## draft striping, sidewalk comments for MMC

From: **Bruce Hyman** <bhyman@portlandmaine.gov>  
 Date: Thu, Dec 13, 2018 at 3:48 PM  
 Subject: Re: draft striping, sidewalk comments for MMC  
 To: Helen Donaldson <hcd@portlandmaine.gov>  
 Cc: Tom Errico <thomas.errico@tylin.com>, Jeremiah Bartlett <jbartlett@portlandmaine.gov>

### C05-02 Upper Congress Street

SHEET NUMBER
C05-2A

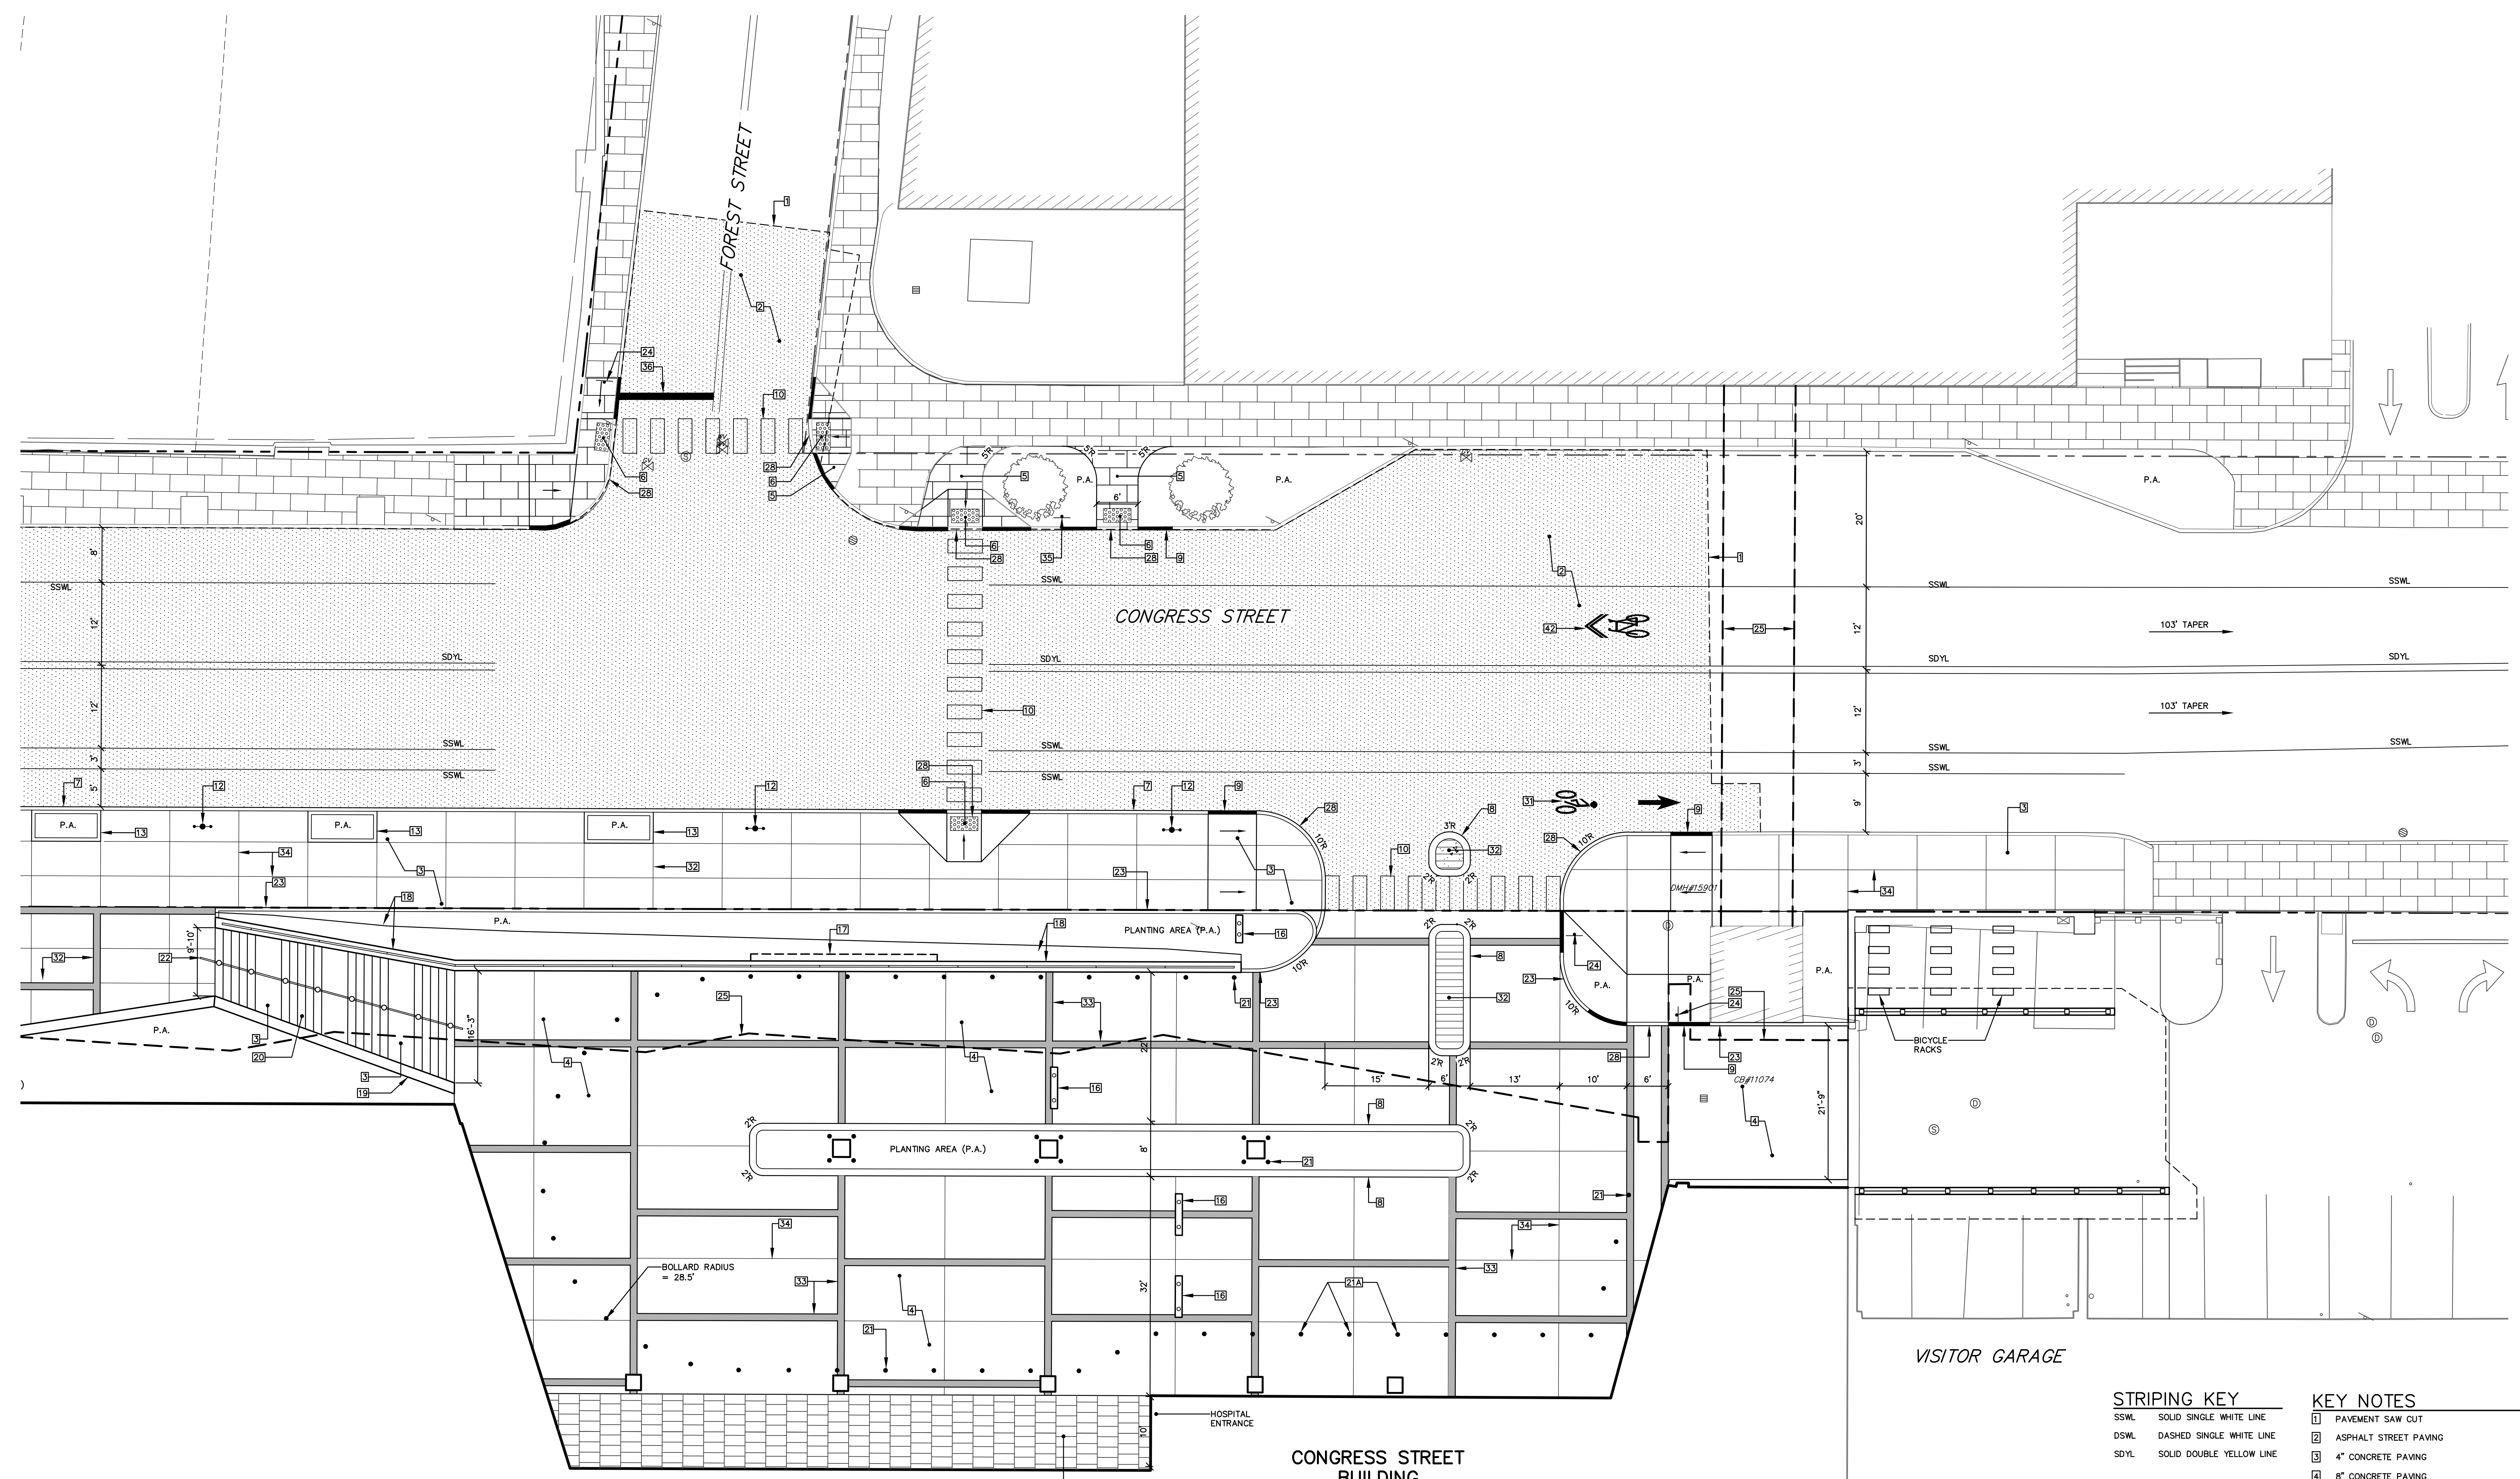
- - Revise striping plan to retain south side parking east of the Visitor's Garage entrance/exit to just west of Bramhall where the climbing lane will transition to Shared Lane Markings (centered in the travel lane). Show (north to south) an 8' parking lane, 11' travel lanes, a 6' climbing bicycle lane, and an 8' parking lane.
  - This section should continue to Bramhall Street to the east. Please provide plans for restriping the entirety of Congress from Valley Street to Bramhall St/Deering Ave. The outside bike lane lines are to be dashed 6" lines for a minimum of 50' in advance of an intersection and through the intersection.

C05-04

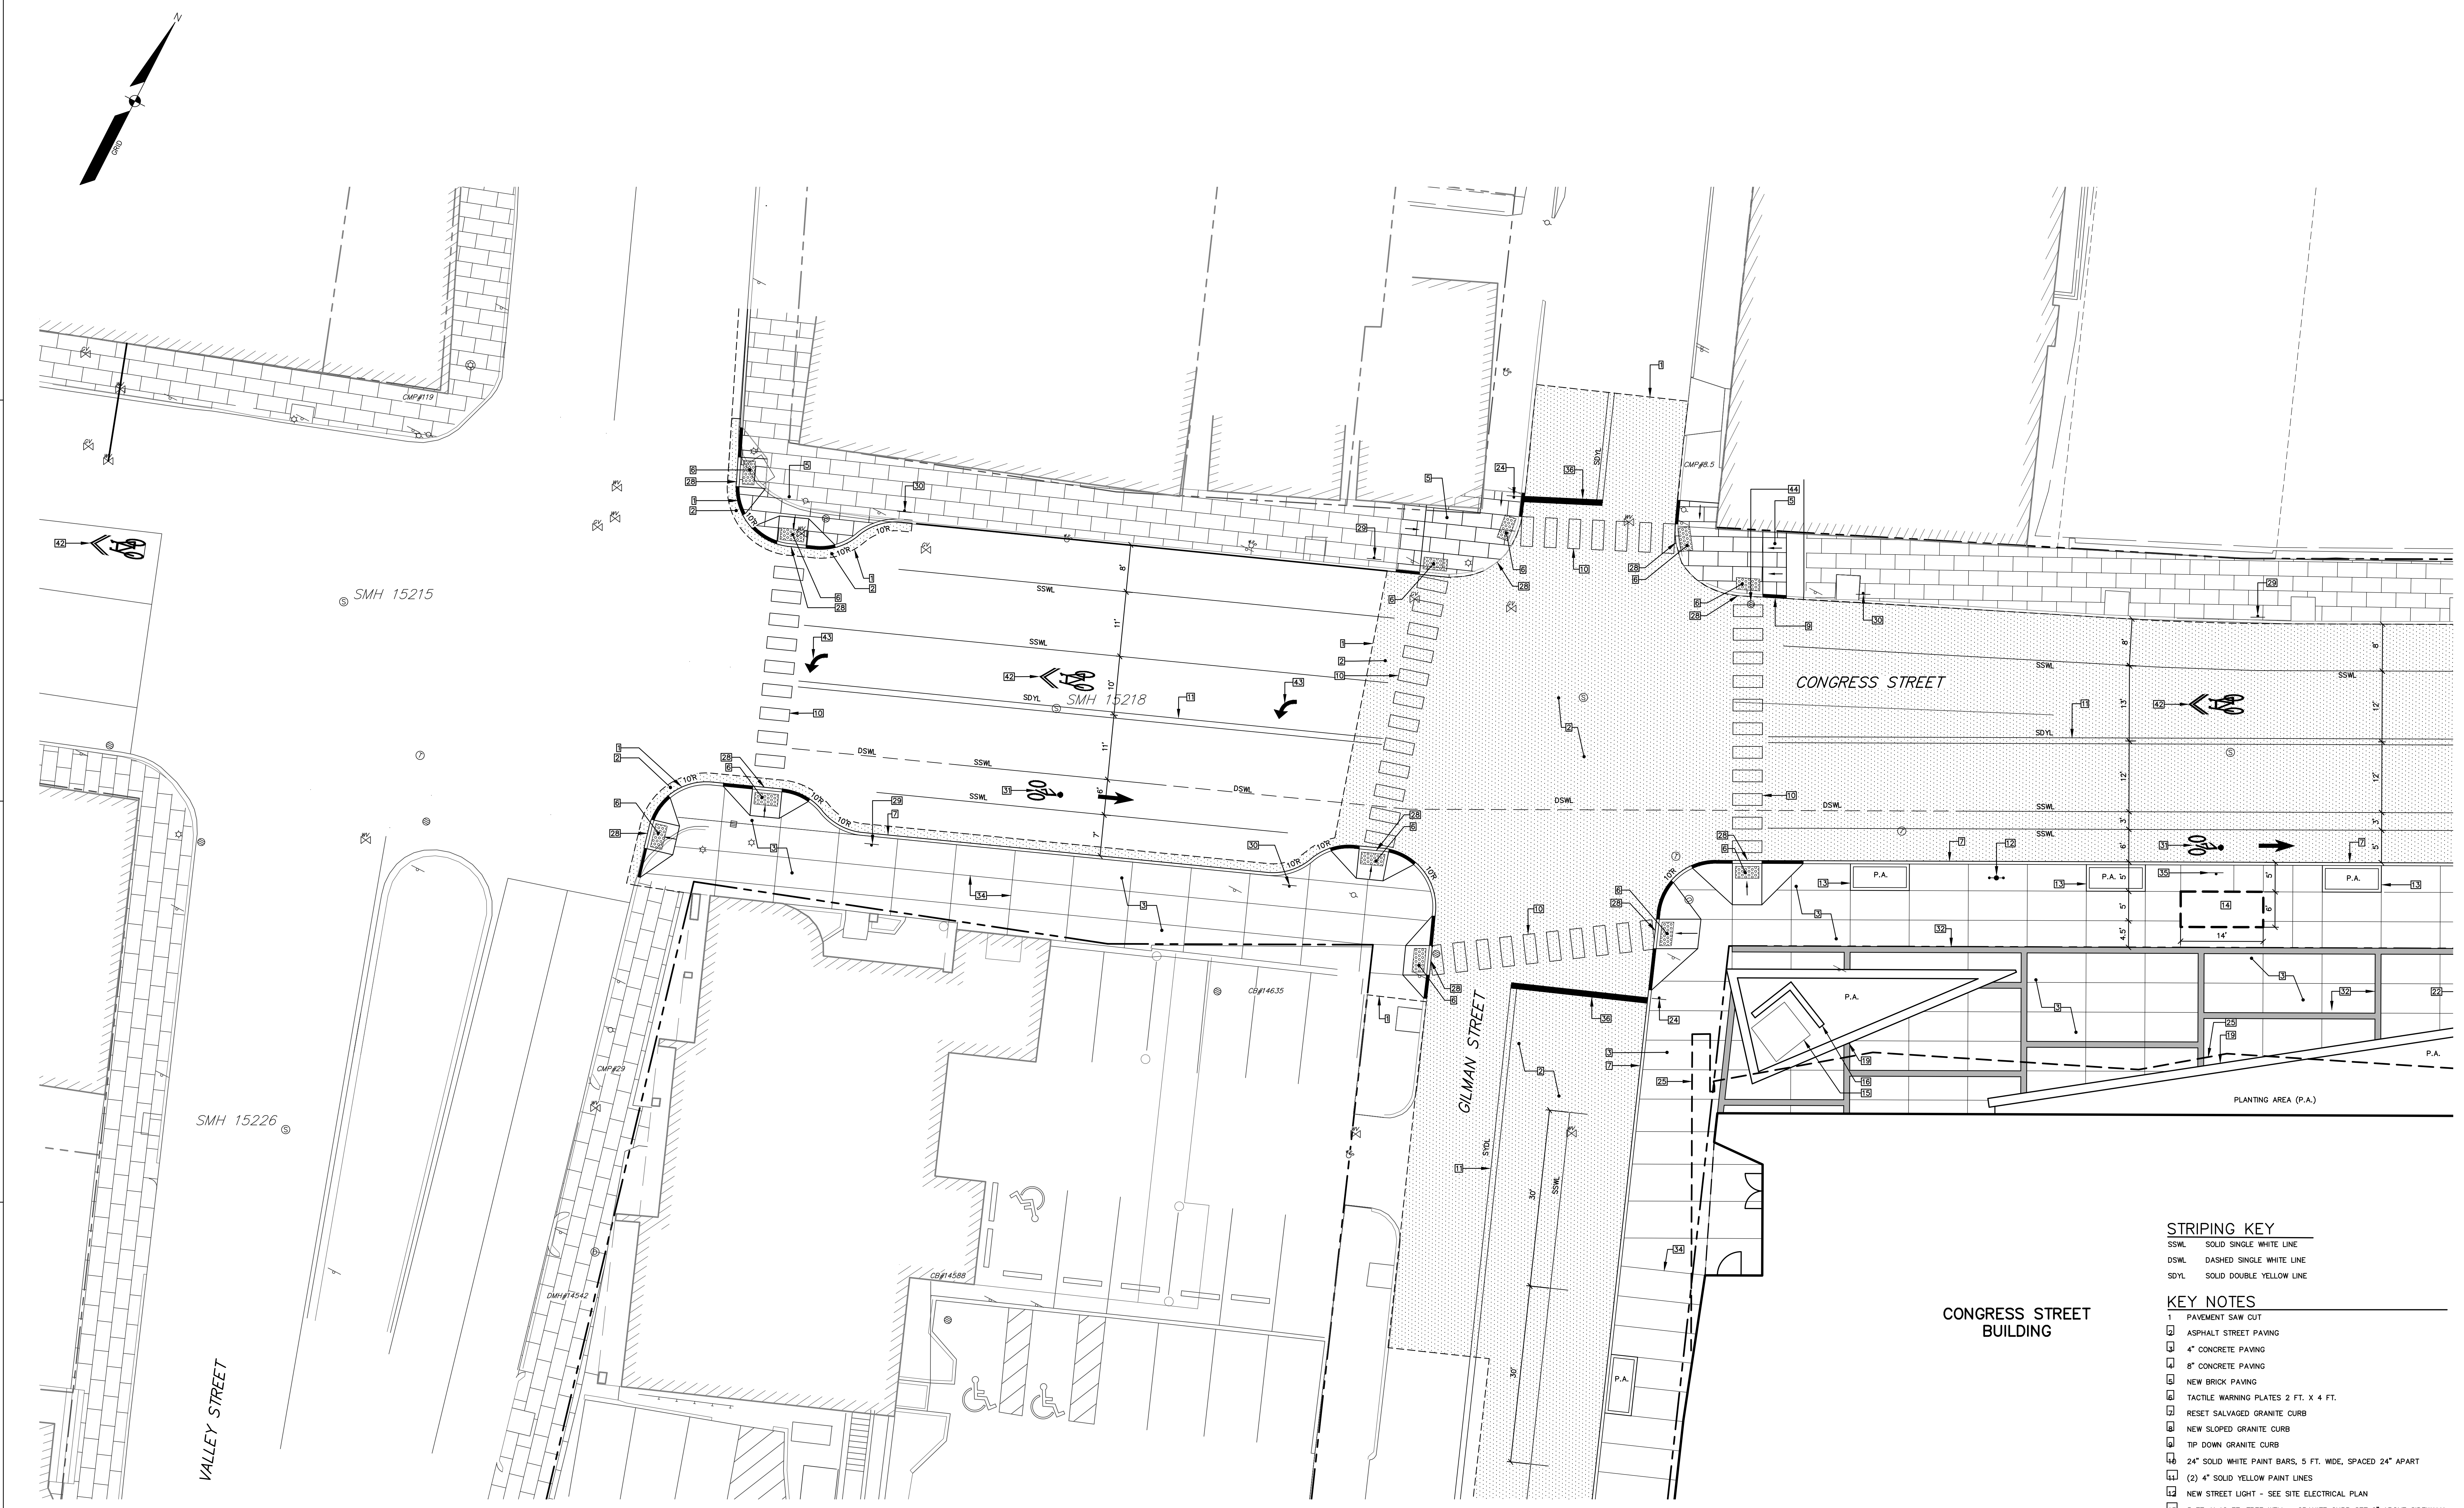
- Provide final details on METRO shelter, including distances to curb and property line. The shelter design may require further review.
- Provide curb re-alignments, possibly to include curb extensions at southwest and northwest corners of Gilman and Congress. Further guidance will be provided.
- Curb extension width should be maximum 6' in extent (measured from curb line), using 10' radii.
- 16' travel lanes are too wide for the WB approach to Valley Street. Retain existing westbound left turn pocket to Valley Street.
- Bike lanes are to be a minimum of 6' adjacent to a parking lane
